BANCOR DEVELOPMENTS PTY LTD

TRAFFIC AND TRANSPORT  
INFORMATION FOR PREFERRED  
PROJECT REPORT IN RELATION  
TO PROPOSED MIXED USE  
DEVELOPMENT, 6 – 16 ATCHISON  
STREET, ST LEONARDS

APRIL 2011

COLSTON BUDD HUNT & KAFES PTY LTD  
ACN 002 334 296  
Level 18 Tower A  
Zenith Centre  
821 Pacific Highway  
CHATSWOOD NSW 2067

**Basement Loading Dock B1**

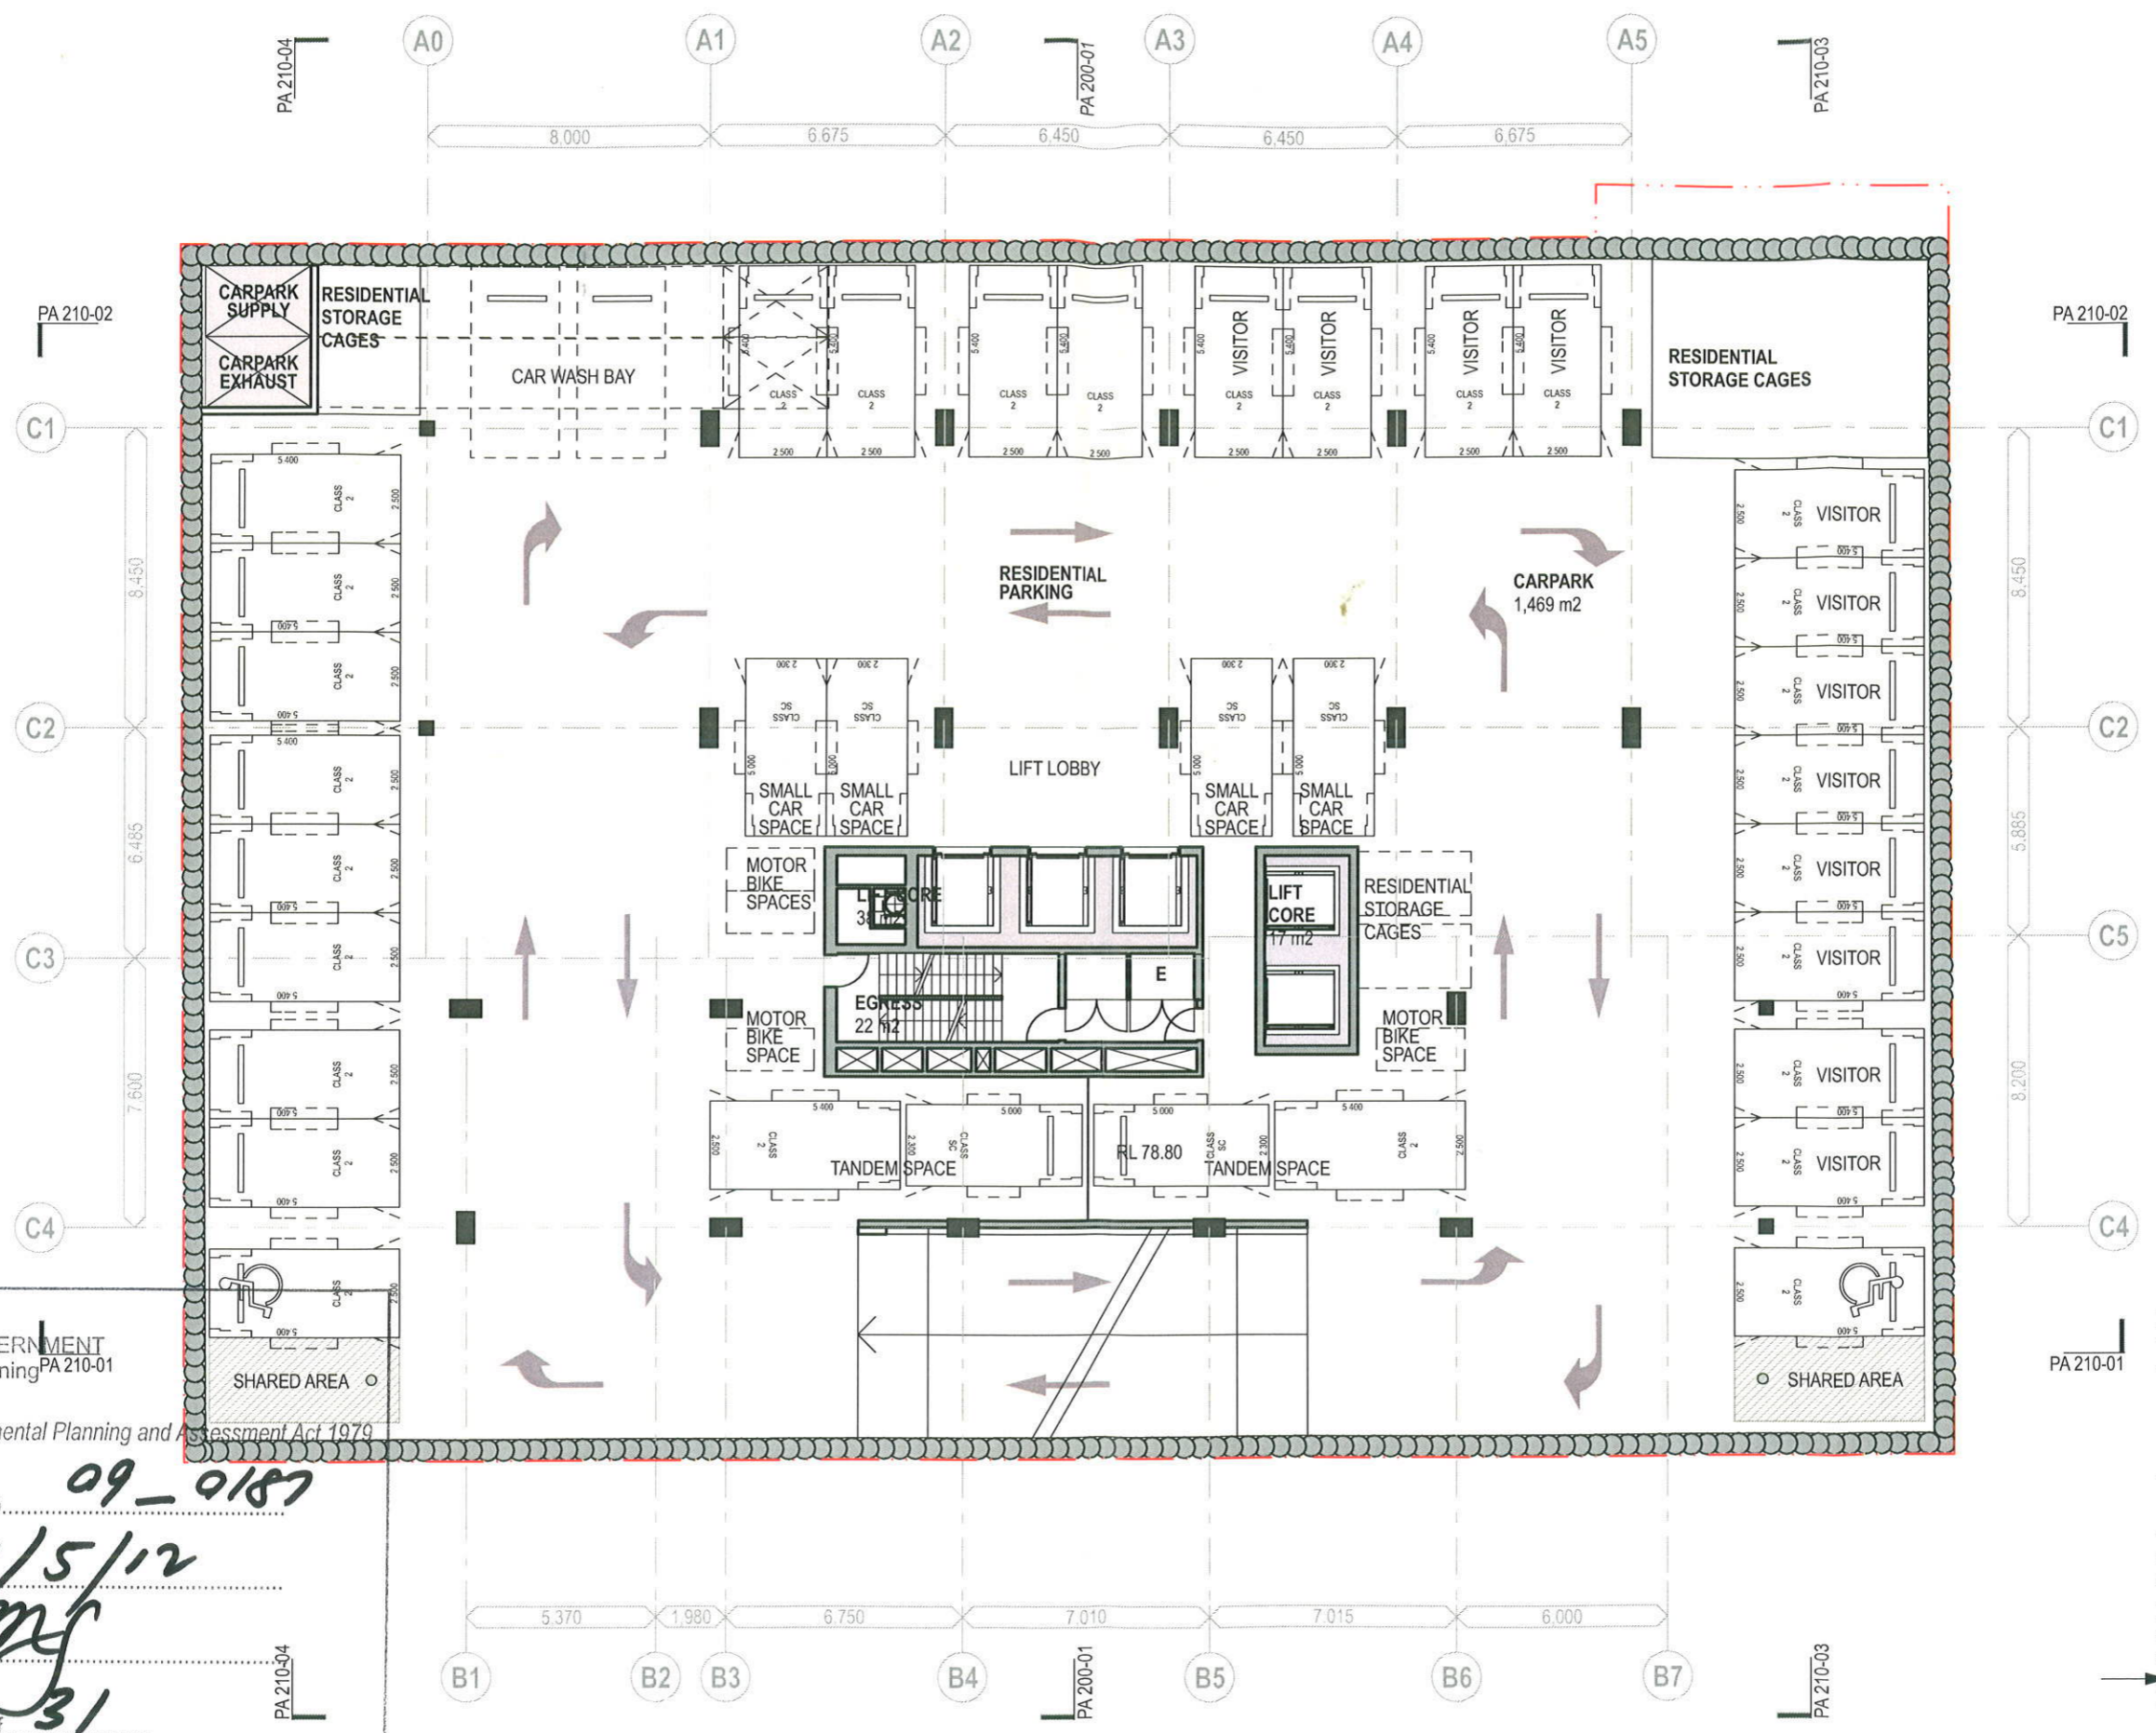
- *Provision of loading docks within the site for 2 vehicles, namely a 10.7m heavy rigid vehicle and a 8.8m medium rigid vehicle, designed in accordance with Australian Standard AS 2890.2 (note: the single loading dock proposed in the basement is too small);*

2.22 DCP 2002 indicates that a loading bay should be provided for the development, with minimum dimensions of 7.6 metres long by three metres wide, with 3.6 metres head room. The proposed loading bay is 8.5 metres long by 3.6 metres wide, with 3.6 metres height clearance, which satisfies this requirement.
